RDC 091476-2 SYD10/00658
MP09_0210
Edmond Platon
8849 2906

**MP09_0154 - PROPOSED MIXED USE COMMERCIAL/RESIDENTIAL DEVELOPMENT
AT 7 RAILWAY STREET, CHATSWOOD**

I wish to advise that the Sydney Regional Development Advisory Committee (SRDAC) considered the traffic impact of this application at its meeting on the 9 September 2010. Below are the Committee's recommendations and RTA's comments on the subject application:

title: Carparking Levels B3 & B2, Floor Plans

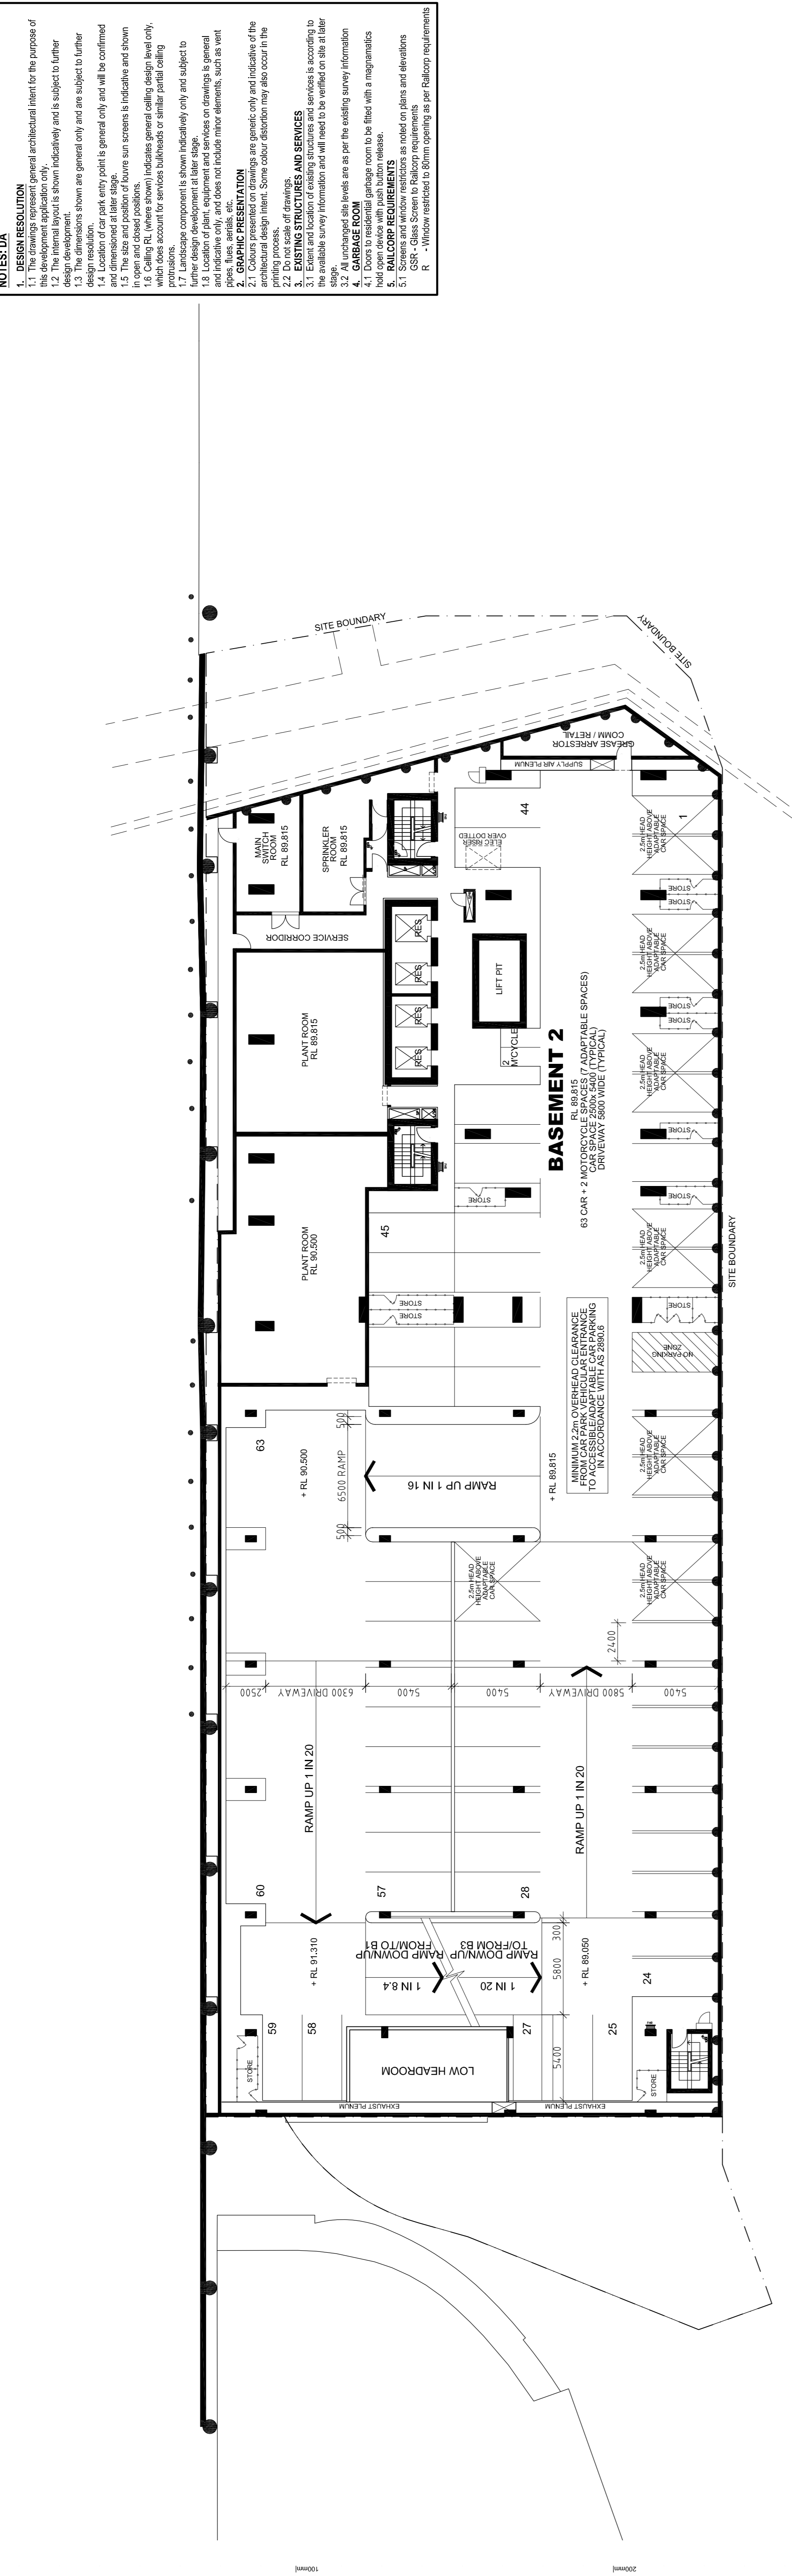
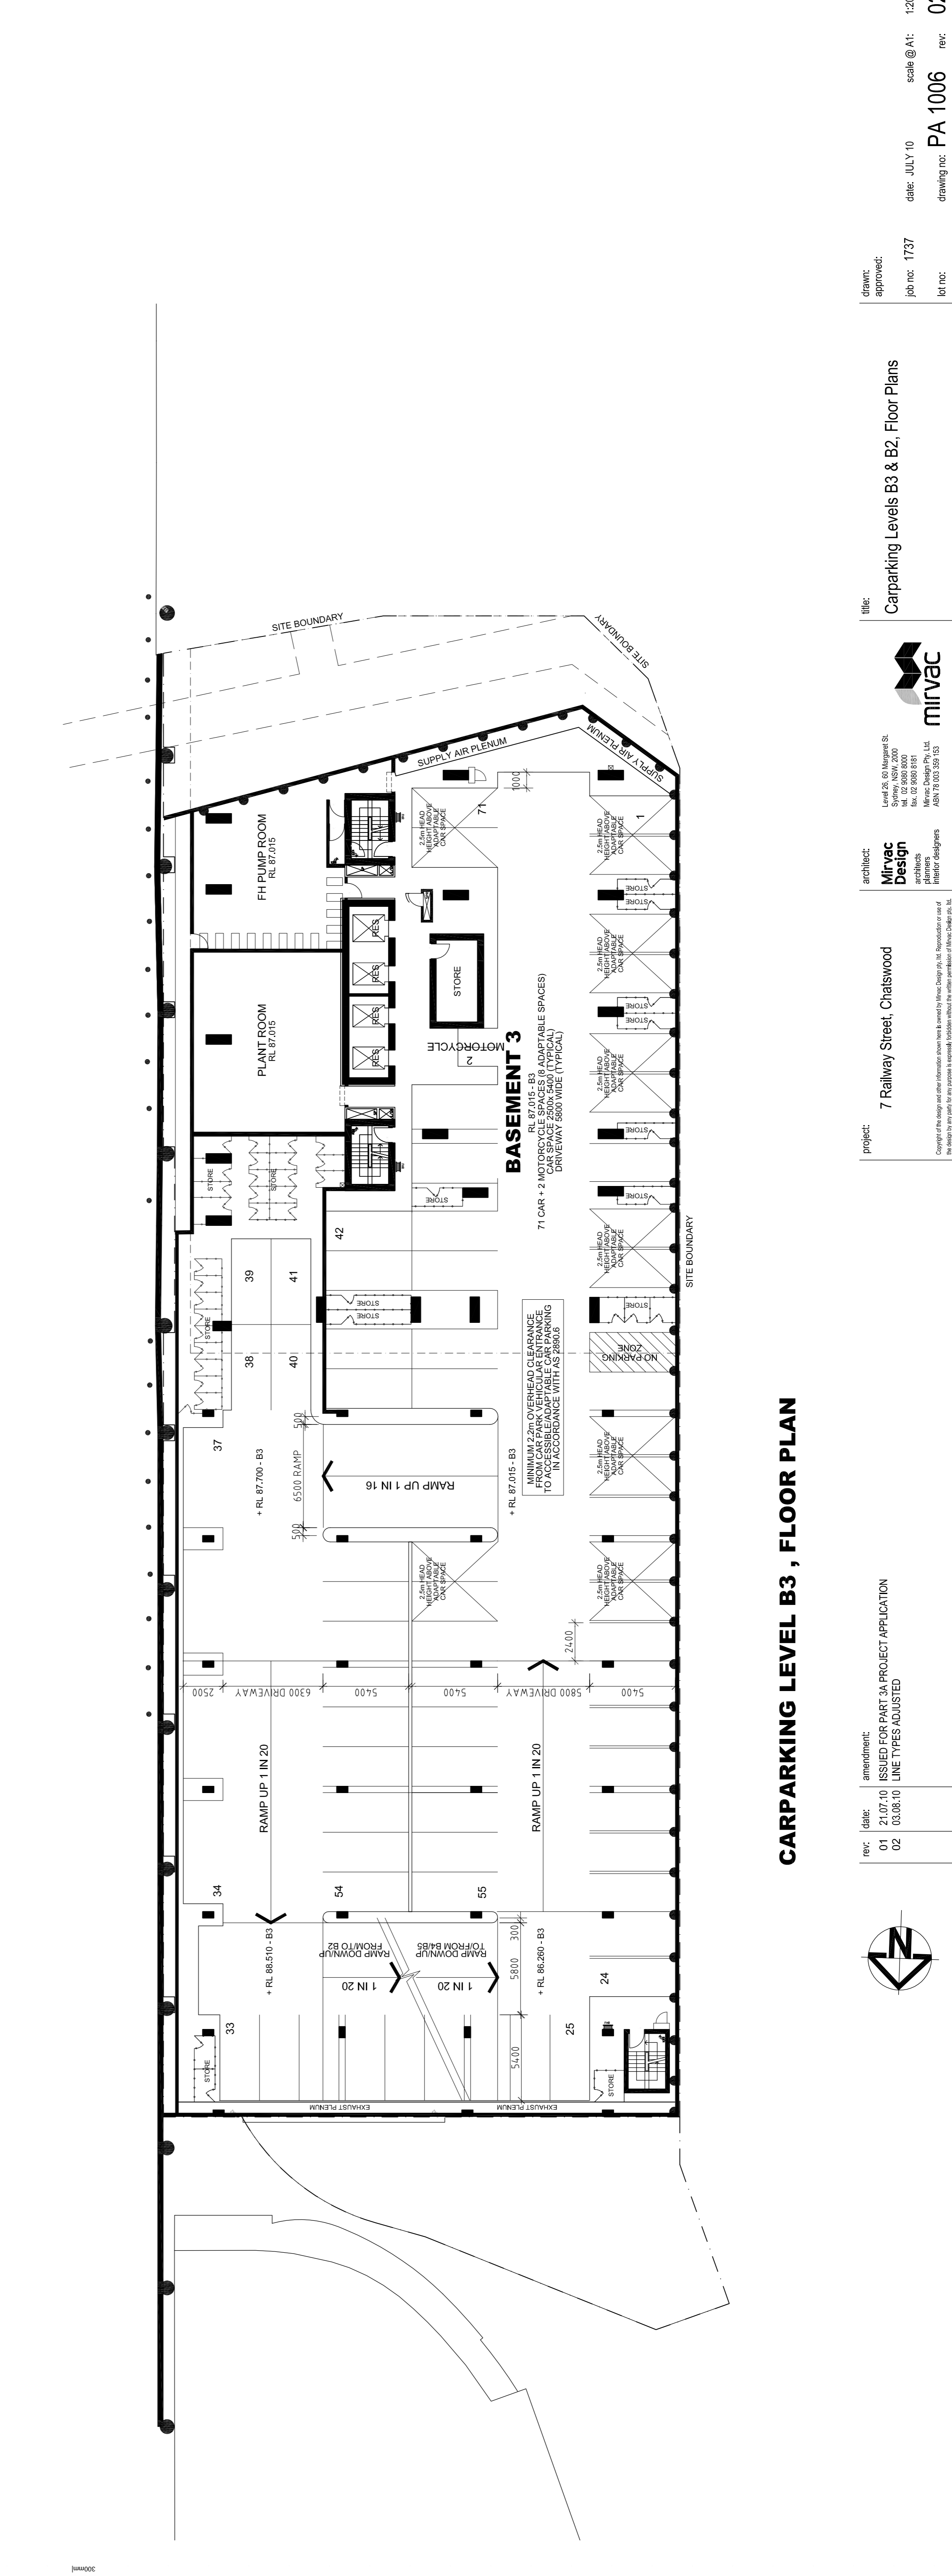
1. An appropriate funding mechanism should be in place to obtain contribution from the developer for traffic signal and road widening on the state road network in accordance with Council's Chatswood Traffic Study.
2. All vehicles should enter and exit the site in a forward direction.
3. All vehicles are to be clear from the edge of carriageway and footpath before being required to stop.
4. Car parking provisions, loading bays and bicycle facilities should be provided to Council's satisfaction.
5. The access driveway, off-street parking and loading areas associated with the proposed development (including driveways, grades, parking aisle widths & aisle lengths, turning paths, sight distance requirements, and parking bay dimensions) shall be re-designed to be in accordance with AS 2890.1 – 2004 and AS 2890.2 – 2002 for heavy vehicles.

6. A Loading Dock Management Plan (LDMP) shall be undertaken to DoP and Council's satisfaction and shall implement appropriate measures that will minimise the conflict between trucks and other vehicles accessing the car park. In addition the LDMP shall outline measures that would prevent another truck entering the site when the loading dock is occupied. The LDMP shall be submitted for approval to Council, prior to the release of the Occupation Certificate.
7. A Demolition and Construction Traffic Management Plan detailing construction vehicle routes, number of trucks, hours of operation, access arrangements and traffic control should be submitted to Council, for approval, prior to the issue of a construction certificate.
8. All works/regulatory signposting associated with the proposed development are to be at no cost to the RTA.
